27 October 2019

**State Significant Development Application Number SSD-10300.**  
**Coffs Harbour Cultural and Civic Space.**

GORDON ST ELEVATION

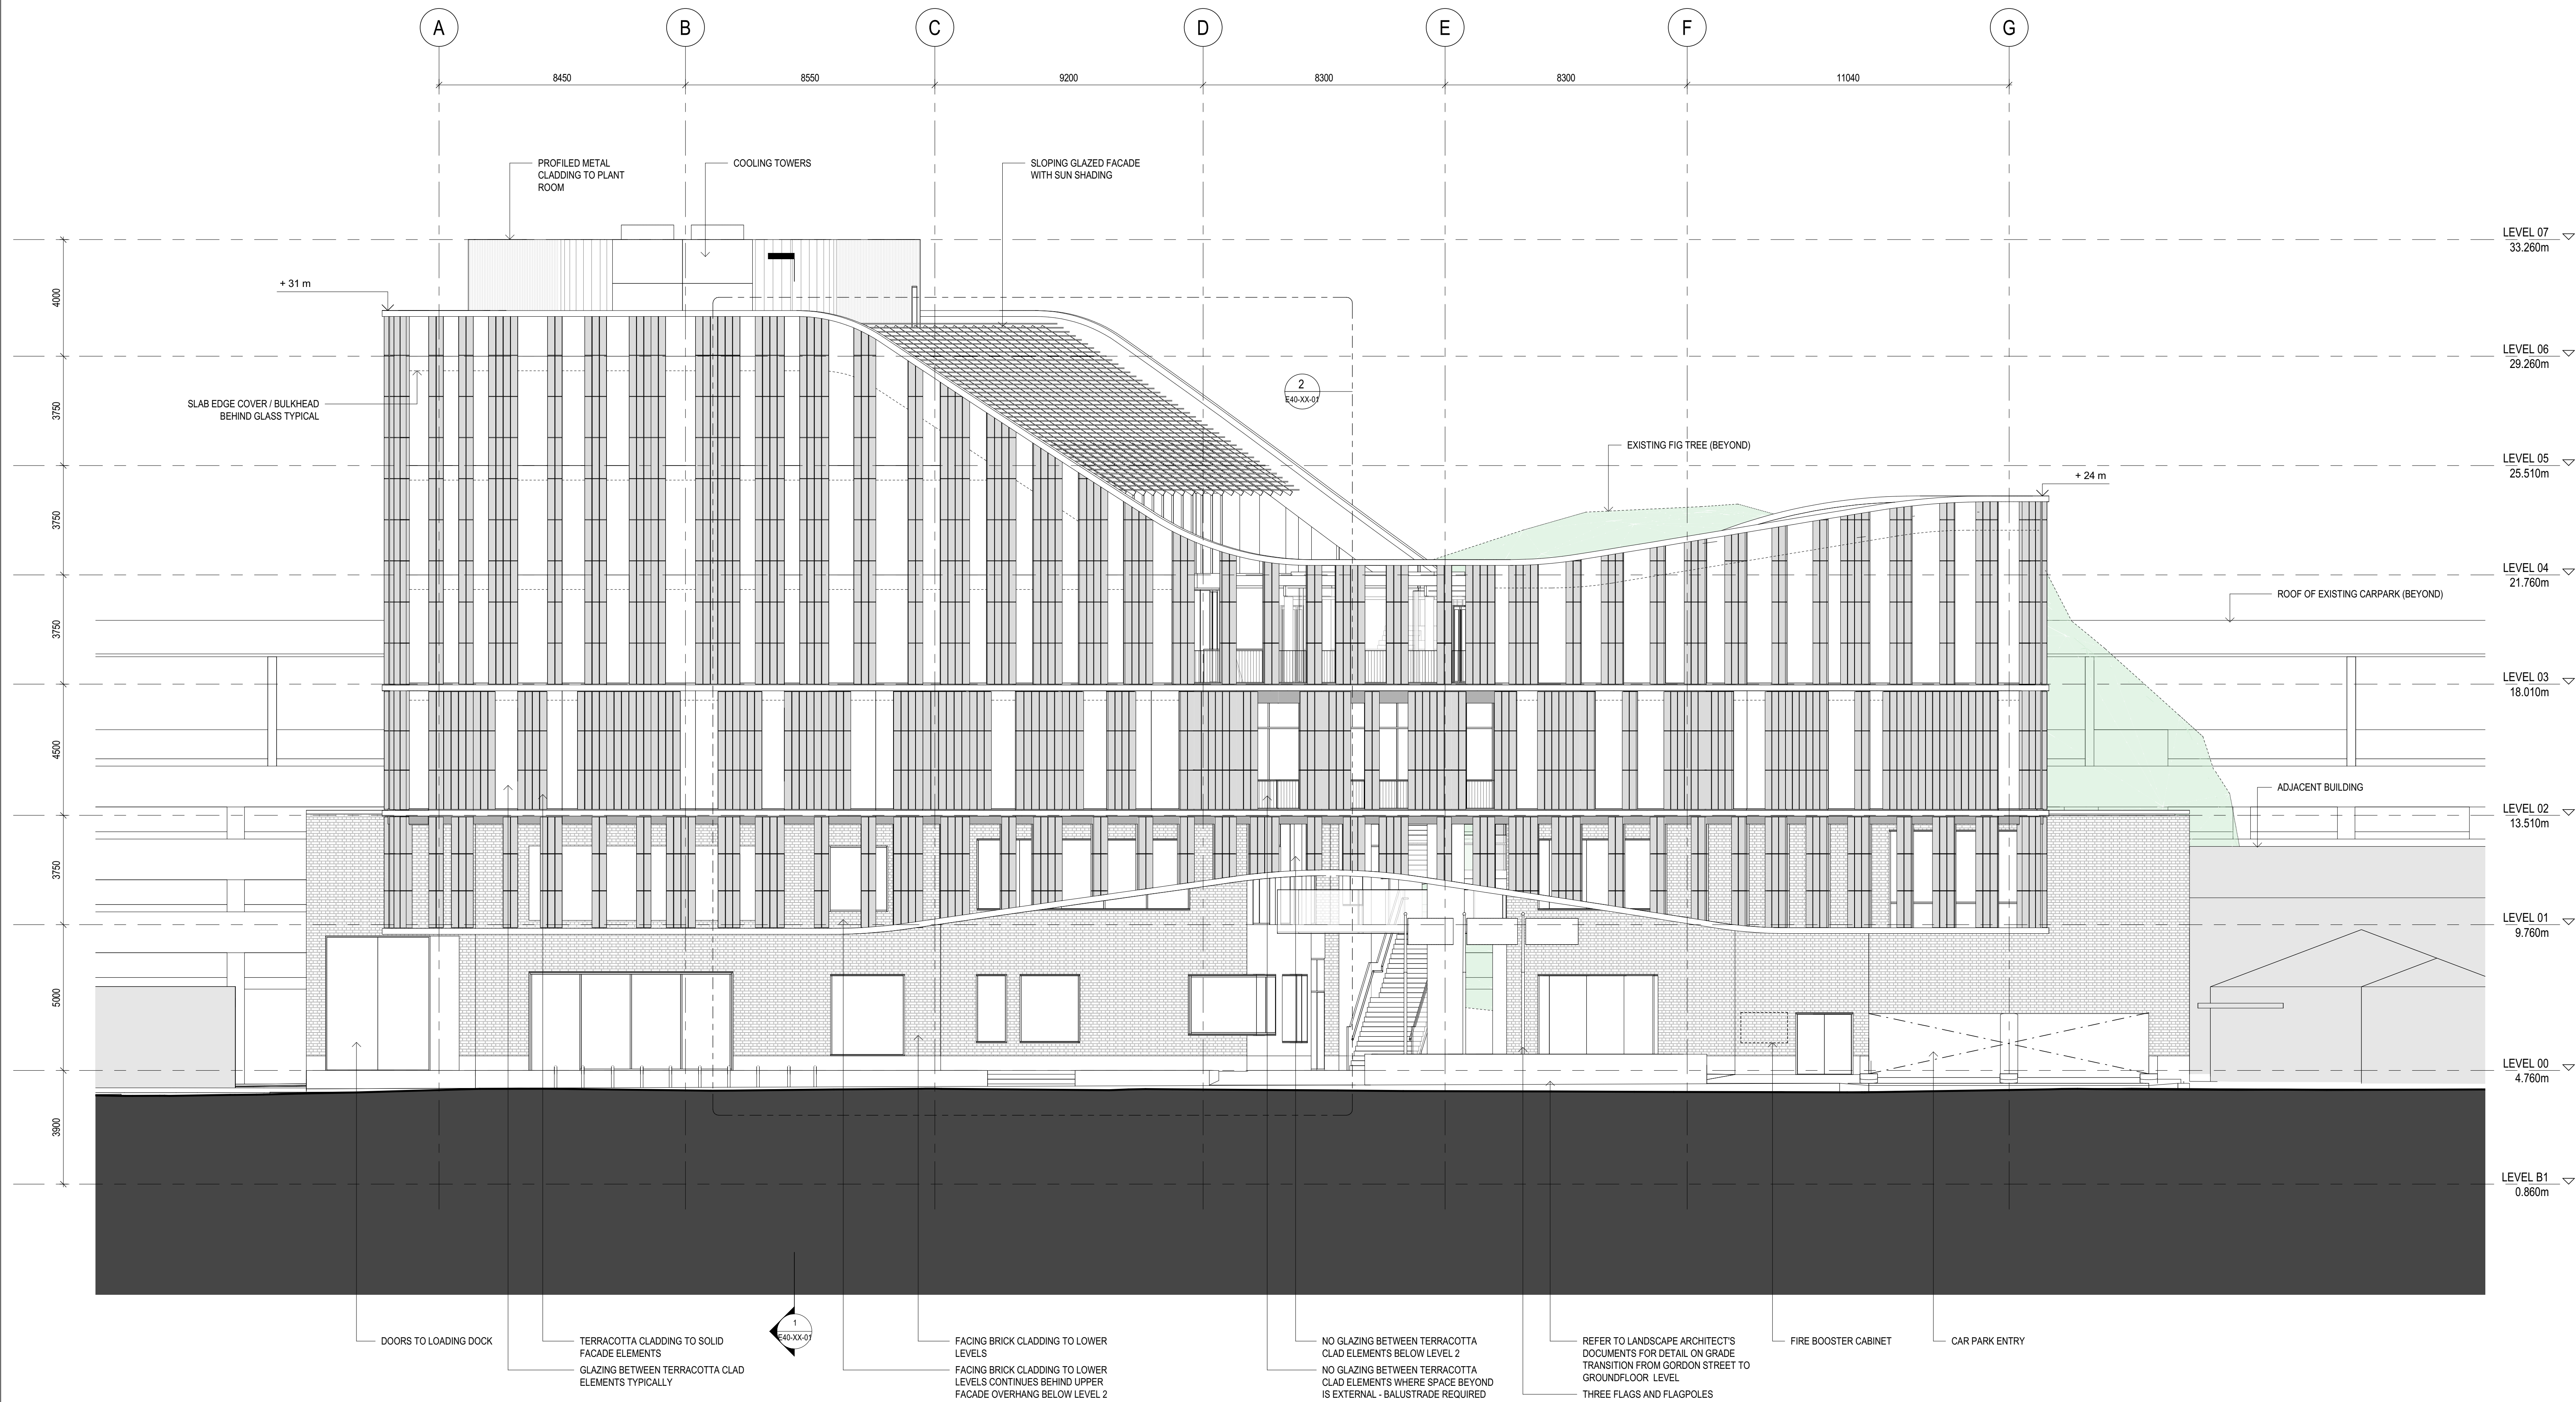
8. It conflicts with the streetscape in Gordon Street in that the proposed building is outside the context of this street having regard to the scale, existing street setbacks, design and general form of the adjoining buildings.
